Recommendation Report for Planning Permission for Works or Extension to a Dwelling

REF NO: FG/219/21/HH

LOCATION: 36 Ferring Lane
Ferring
BN12 6QT

PROPOSAL: Proposed re-roofing of existing conservatory and adjustment of existing conservatory fenestrations.

Drg No.	In conjunction with:-	Rev.
2021/17/1		A

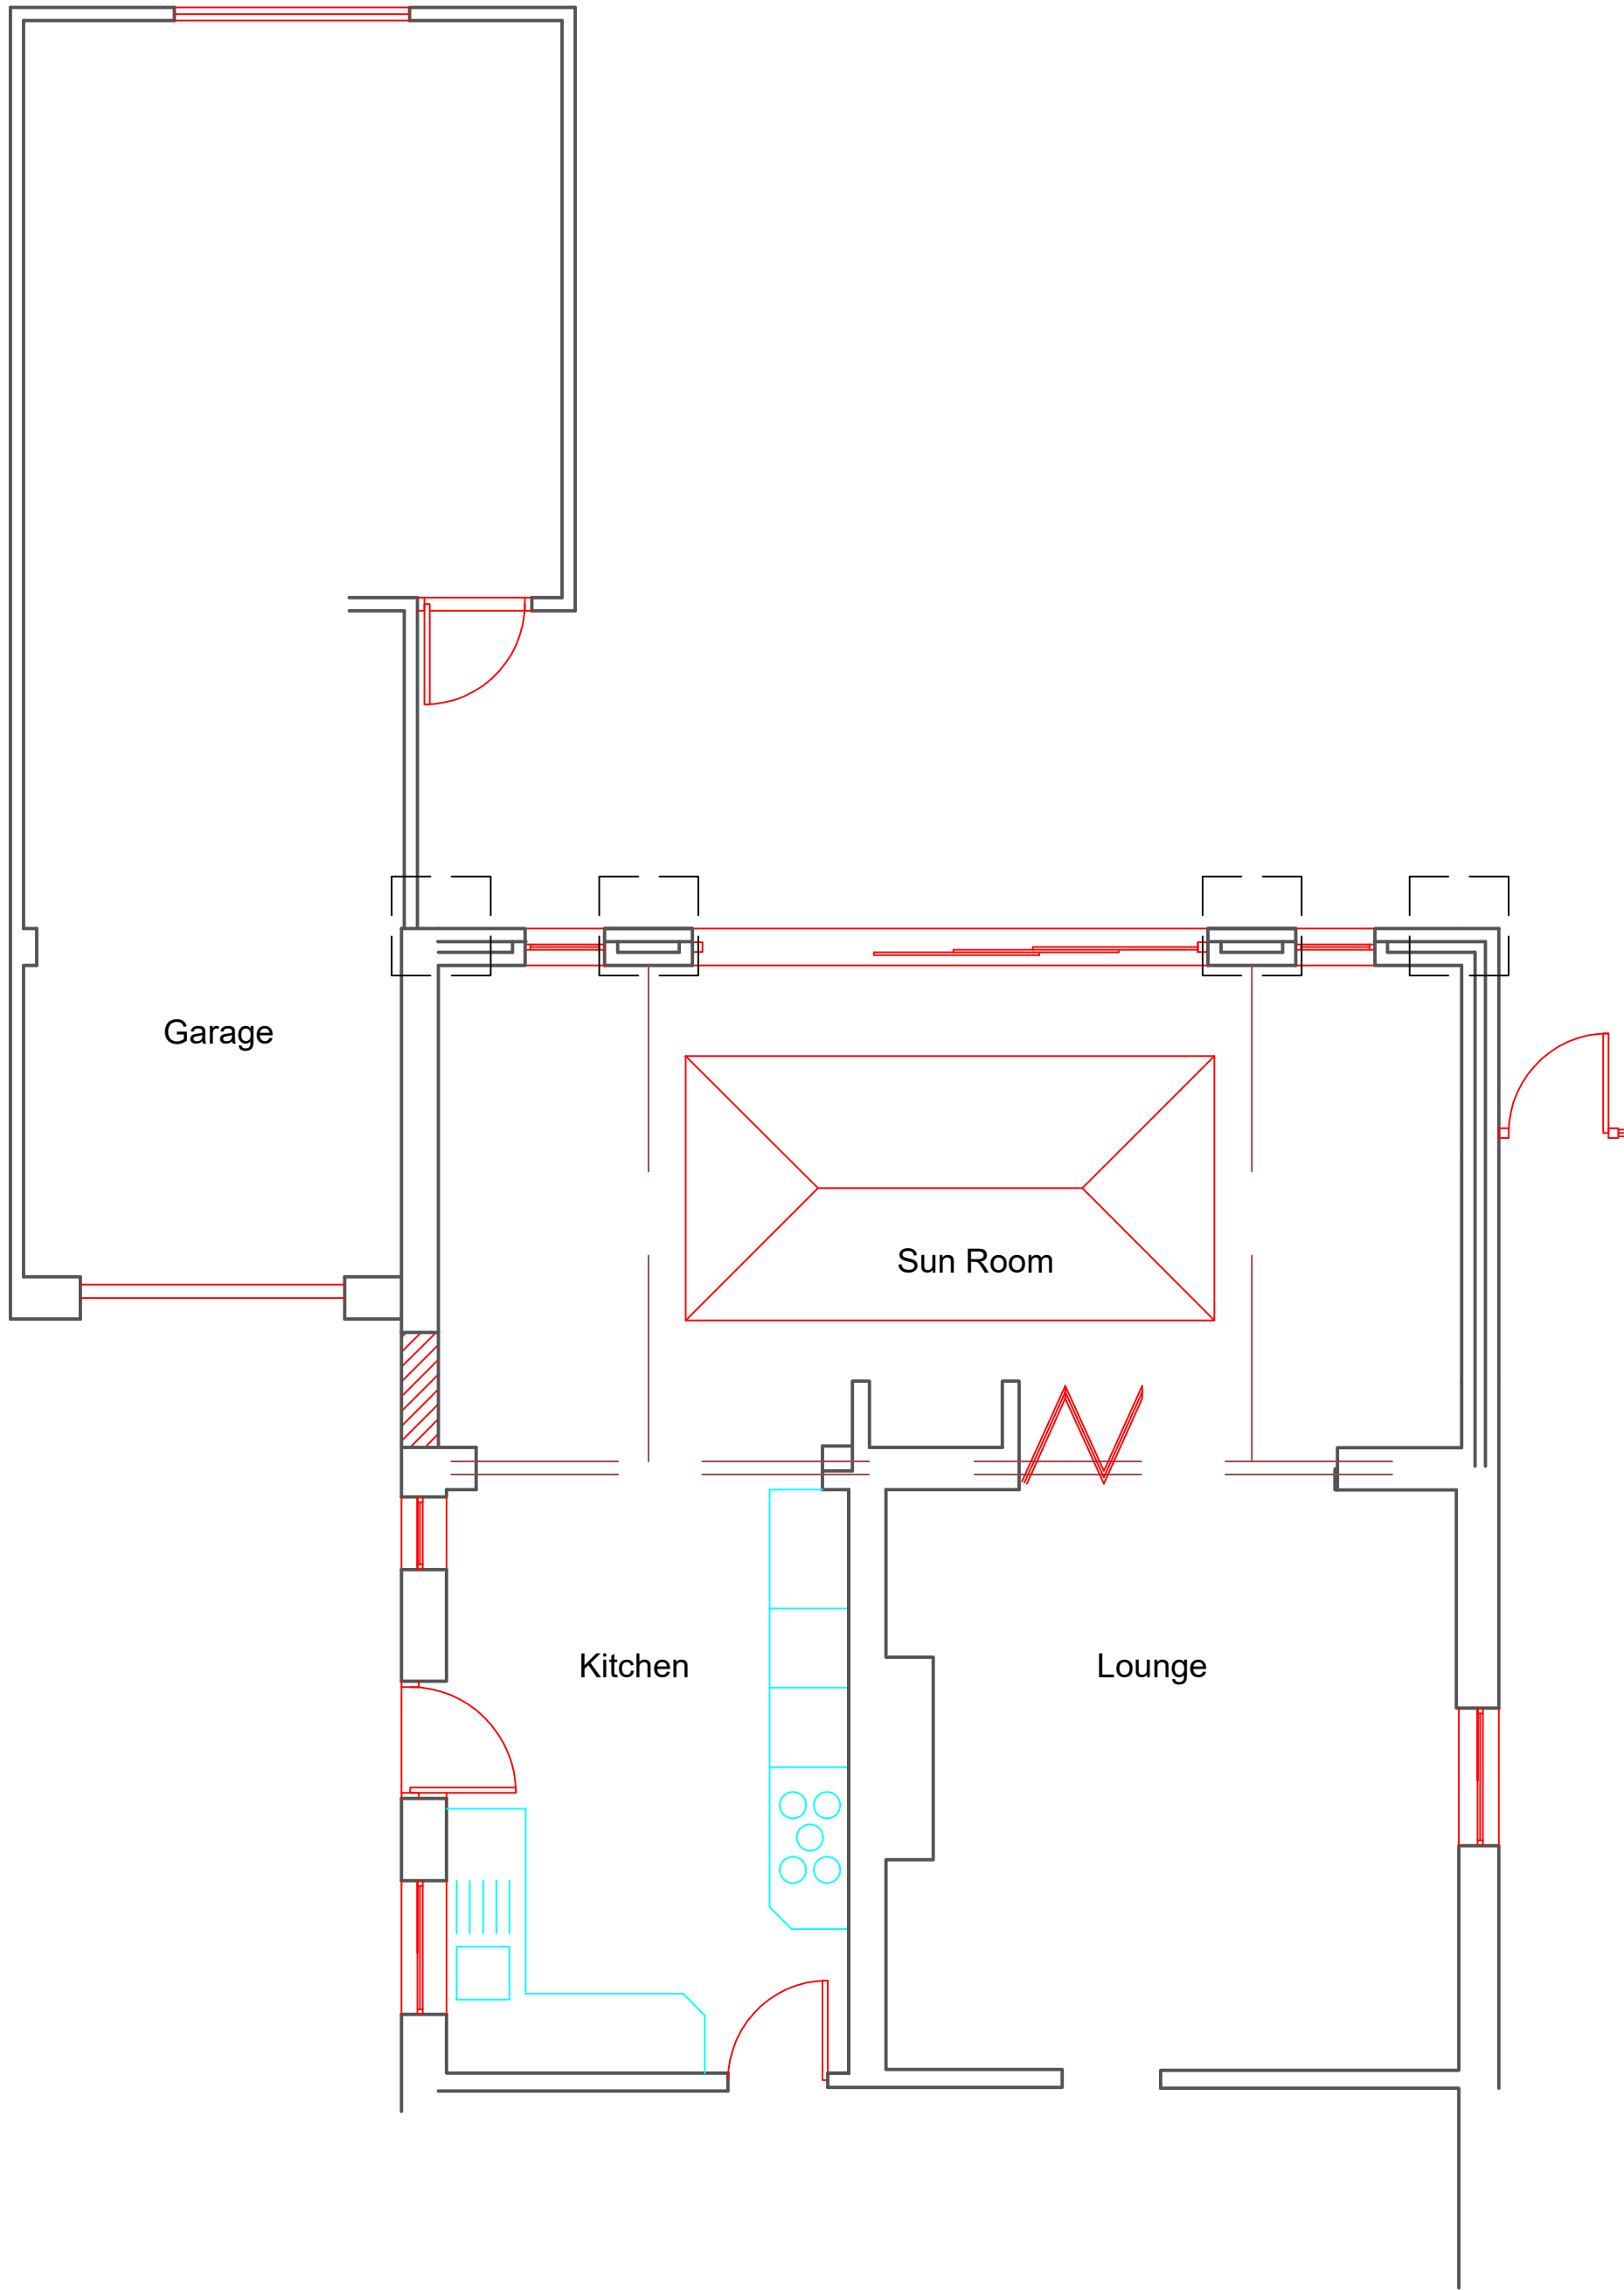
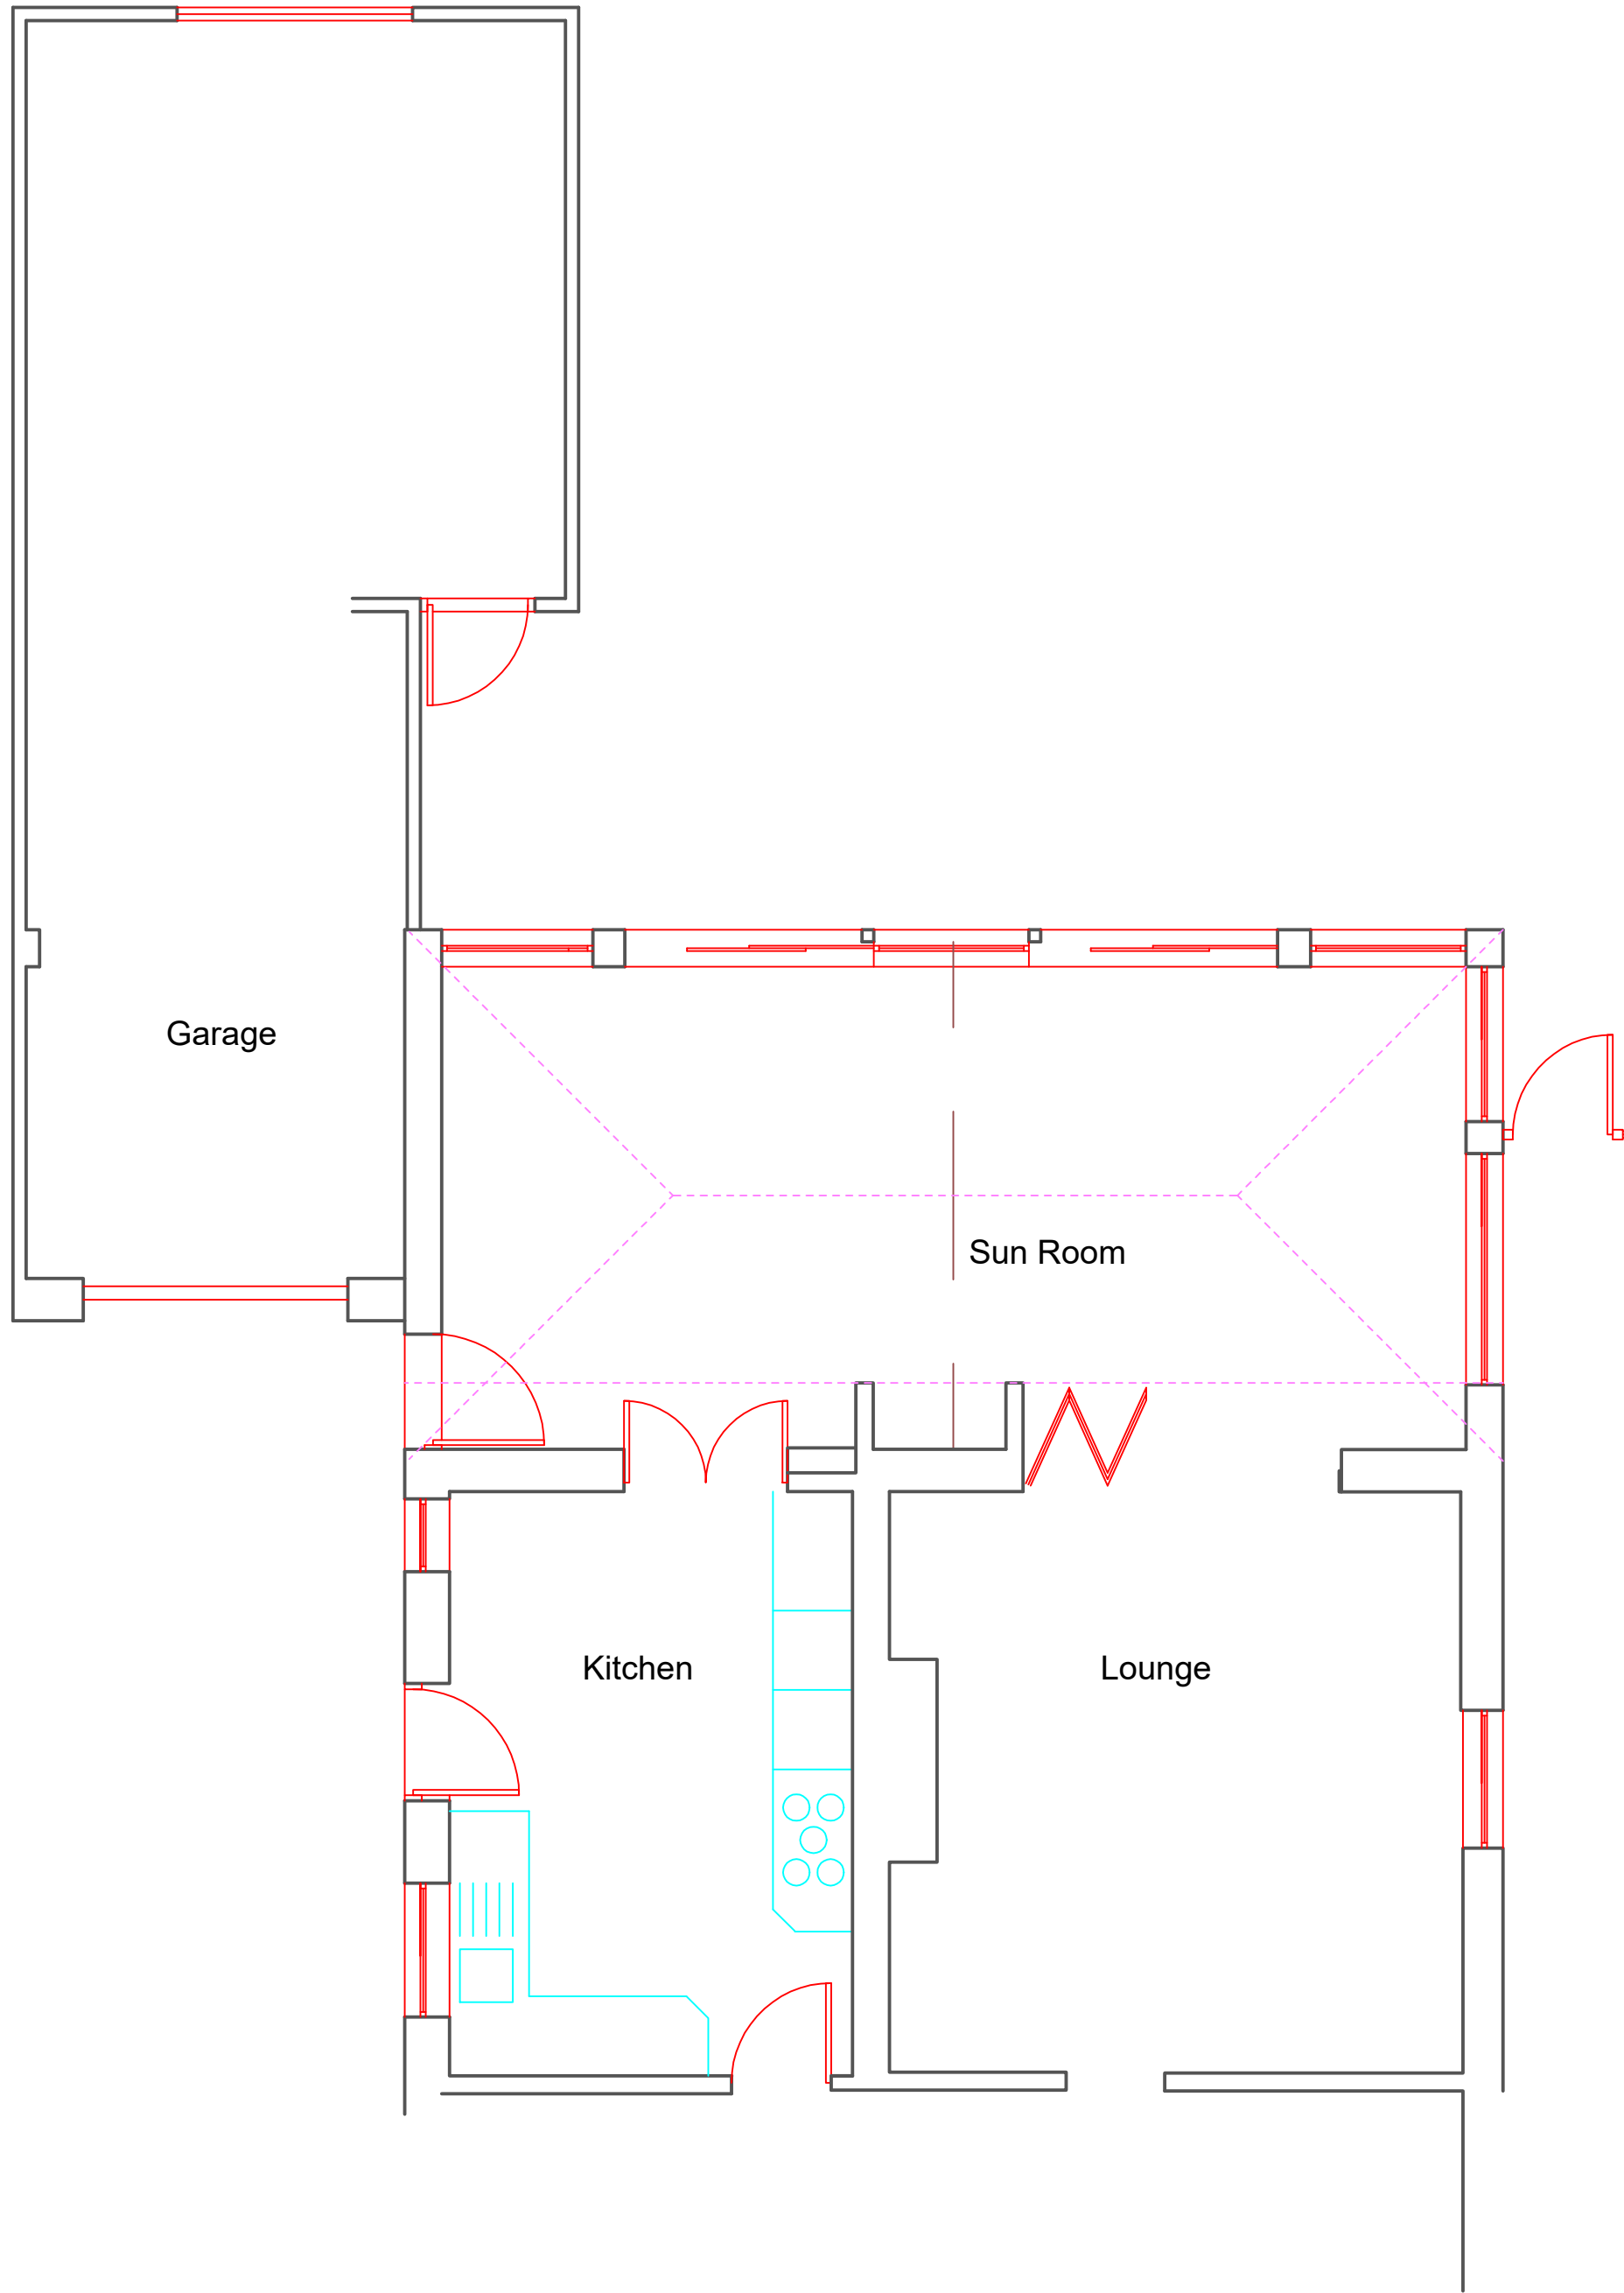
The host dwelling is a large, detached single storey dwelling with an existing rear conservatory that features a glass pitched roof design. The existing conservatory also features windows and glass doors on the southern and western elevations. The proposal seeks to convert the existing roof to a flat roof design featuring a large central rooflight, to remove the western elevation windows and make alterations to the southern elevation windows and doors.
